Please ask for: Ms Iqraa Malik
Email: iqraa.malik@terraquest.co.uk
Telephone: 0121 234 1390
Our Ref: P/125/21/HH
Your Ref:
Date: 1st September 2021

Application for Planning Permission for Works or Extension to a Dwelling

Development: Proposed Window Replacement (This application may affect the setting of a listed building)
Location: Neals Farmhouse West Wing Lower Bognor Road, Lagness Lagness Chichester PO20 1LW

1:500 scale print at A4, Centre: 490218 E, 100459 N

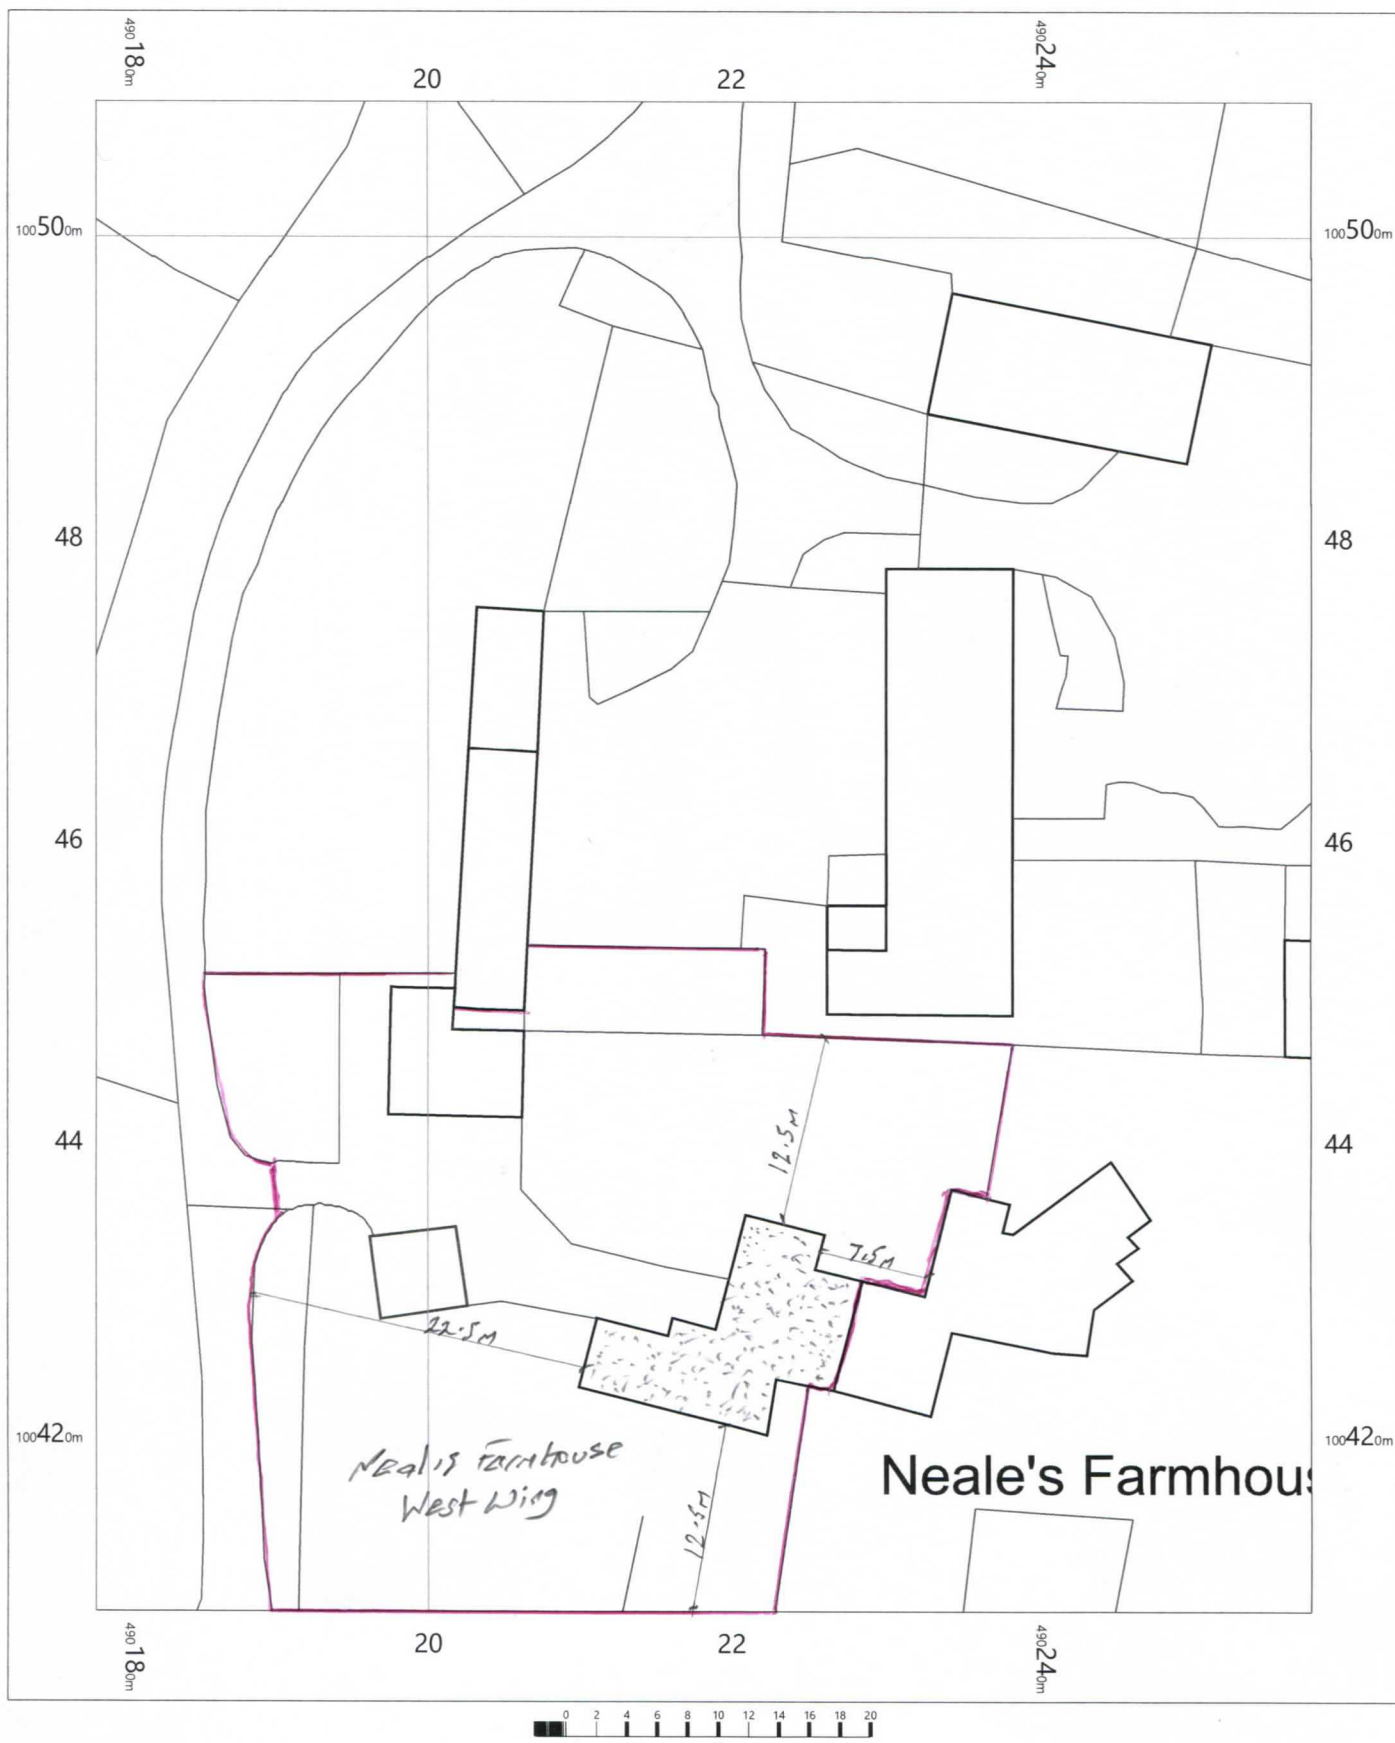
Location Plan

The location plan requires a solid red outline around the site boundary. Please amend. Further details of what must be included on the plan can be found in the Validation Requirements List.
